## CITY OF MERCER ISLAND

WCF20-013/SEP20-021 Review

RE: WCF20-013/SEP20-021, 8215 SE 78<sup>th</sup> St

SHEET TITLE
**EXISTING SITE SURVEY
 SEC 25, TWP 24 N, RNG 4 E, WM**

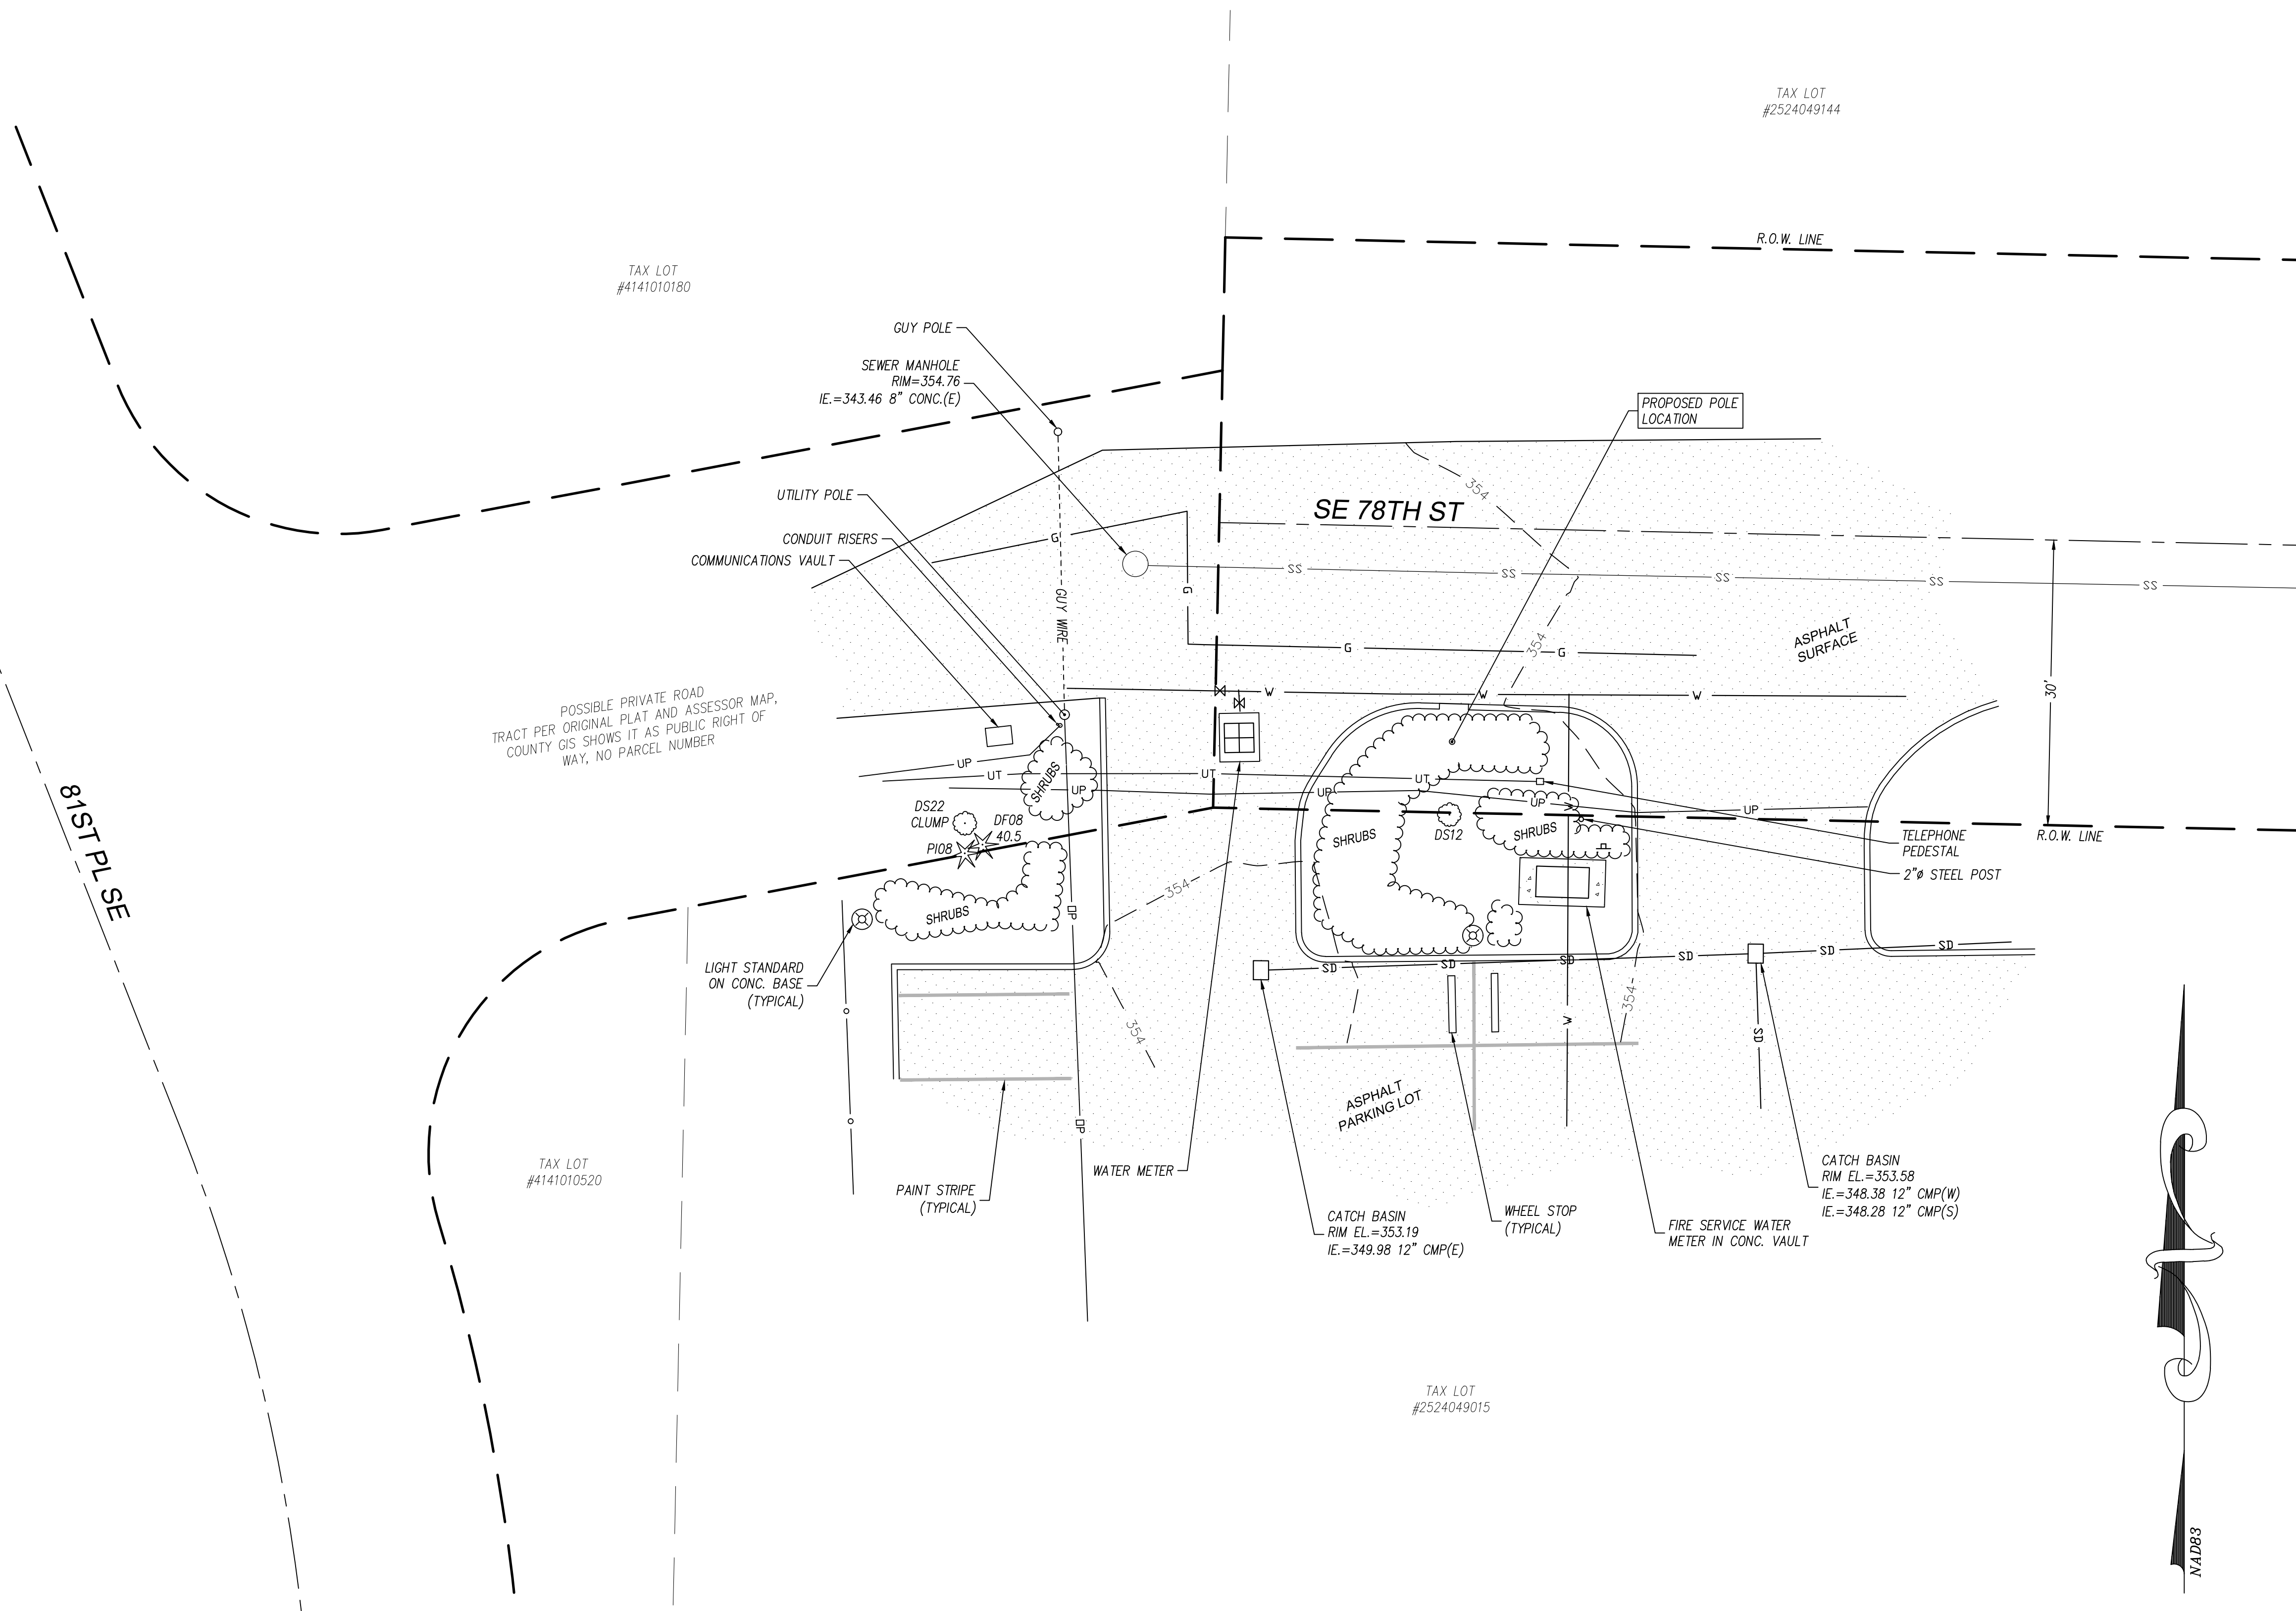
2. During the pre-application meeting, it was asked that alternative pole location areas be explored. The proposed location is close to Tree 1, which is stressed without irrigation and limited soil volume. This proposal would reduce soil volume further, prune roots, and prune branches. Please consider an alternate location that will not result in potential damage to Tree 1.

SHEET TITLE:
SITE PLANS

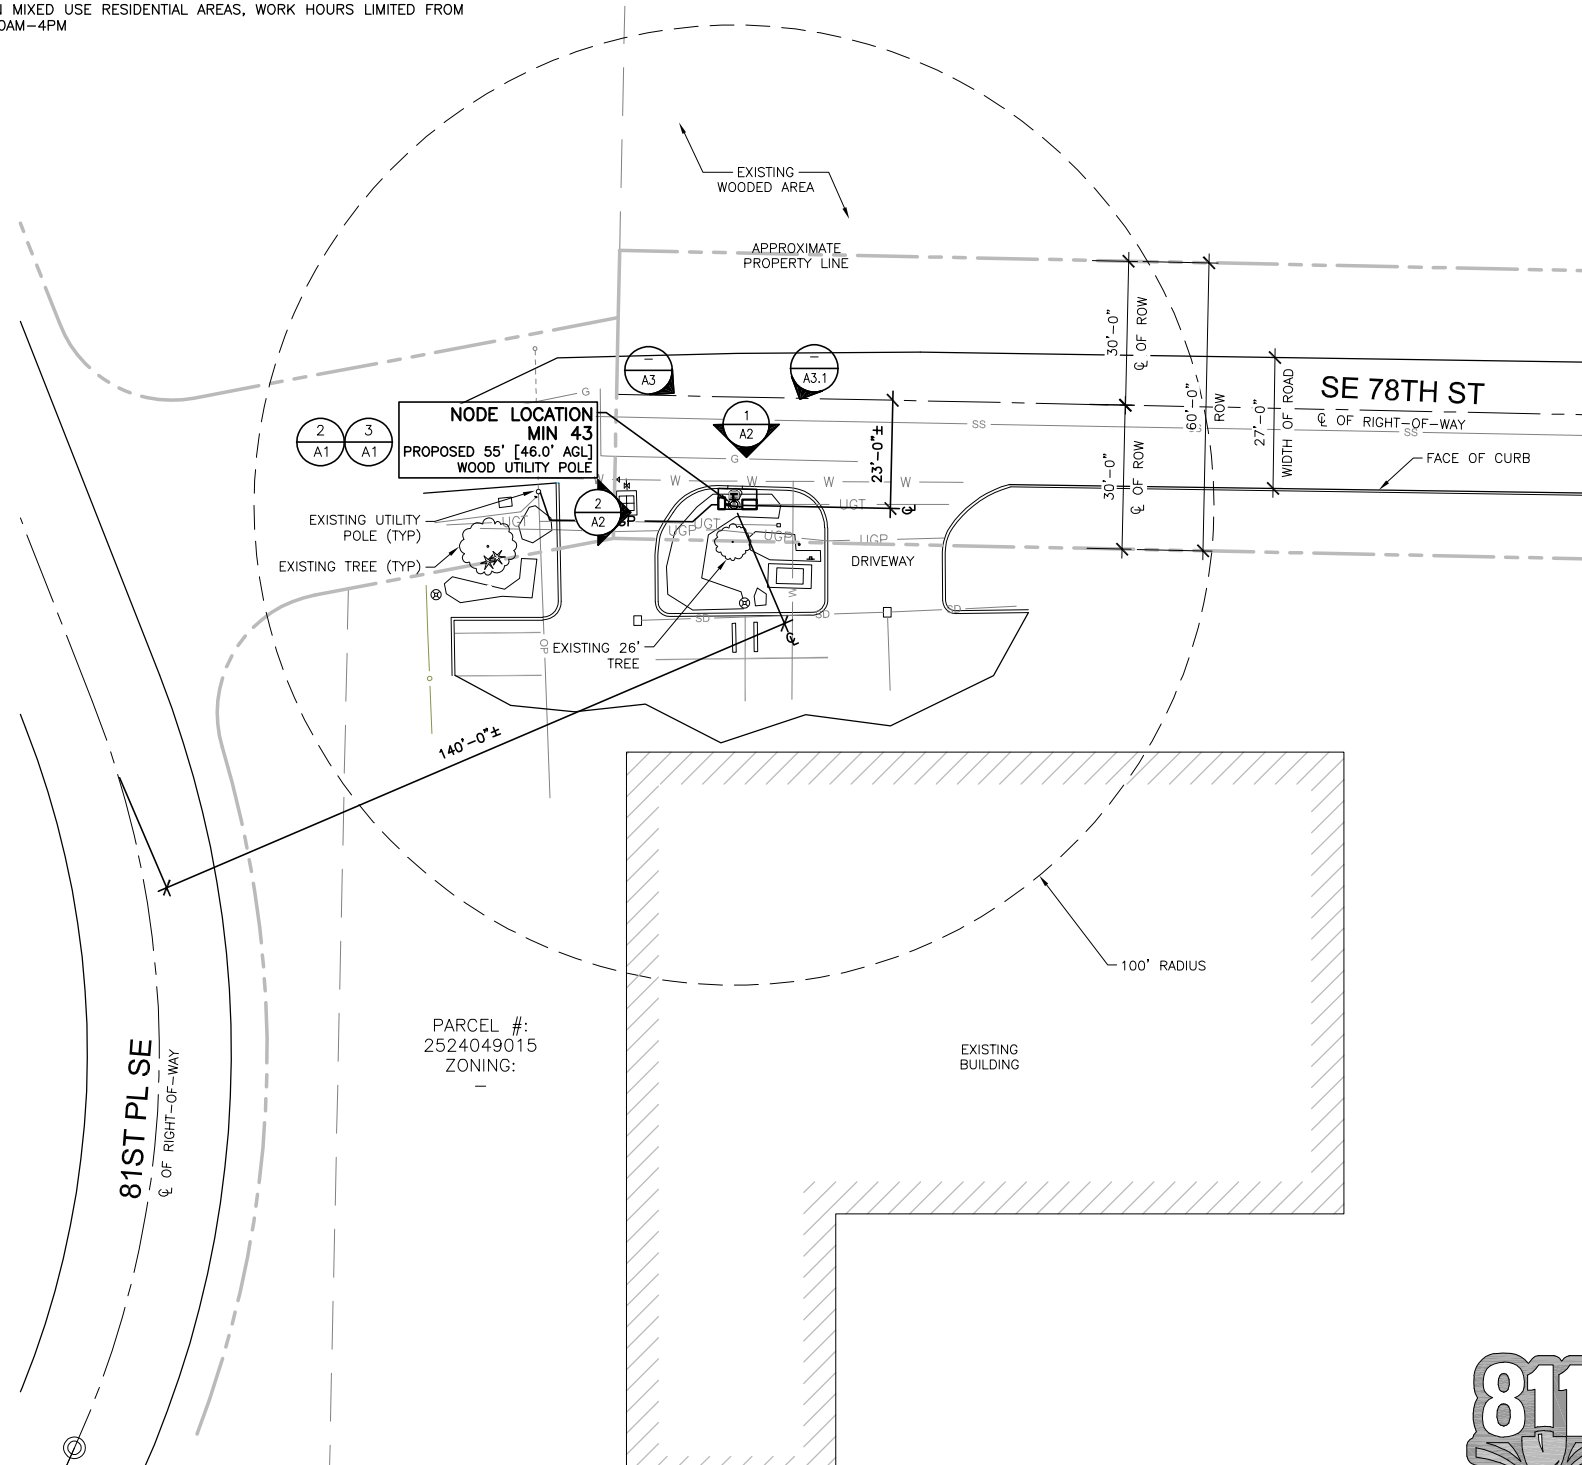
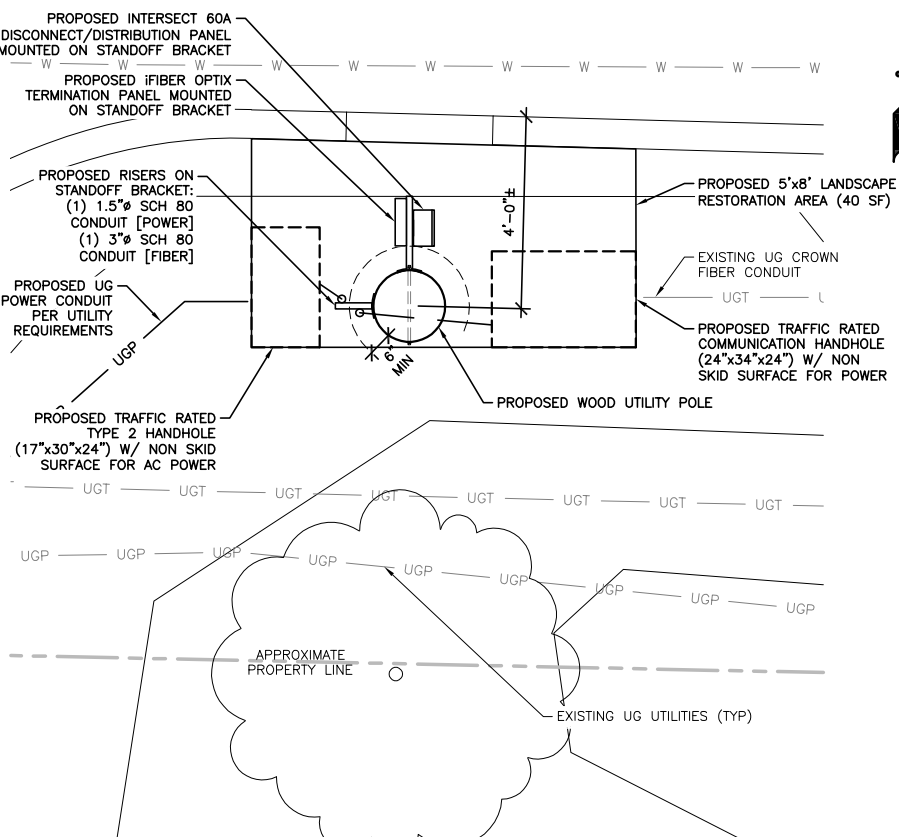
1. MICC 19.06.075(F)(1)(a) states that new poles within the rights-of-way are only permitted if the applicant can establish that the proposed small cell facility cannot be located on an existing utility pole, electrical transmission tower or on a site outside on the public rights-of-way such as a public park, public property, building, transmission tower, or in a nonresidential use in a residential zone whether by roof or panel mount or separate structure. Please demonstrate why the small cell facility cannot be placed in the locations listed in MICC 19.06.075(F)(1)(a), in particular:

- The utility poles in the right-of-way of 84<sup>th</sup> Ave SE
  - Within the South Mercer Playfields, a public park on the north side of SE 78<sup>th</sup> St. There are light poles at the park's parking lot near the proposed location of the small cell facility.

- Within the property of Lakeridge Elementary School. There are light poles within the school's parking lot near the proposed location of the small cell facility.

- On the nearby school building.
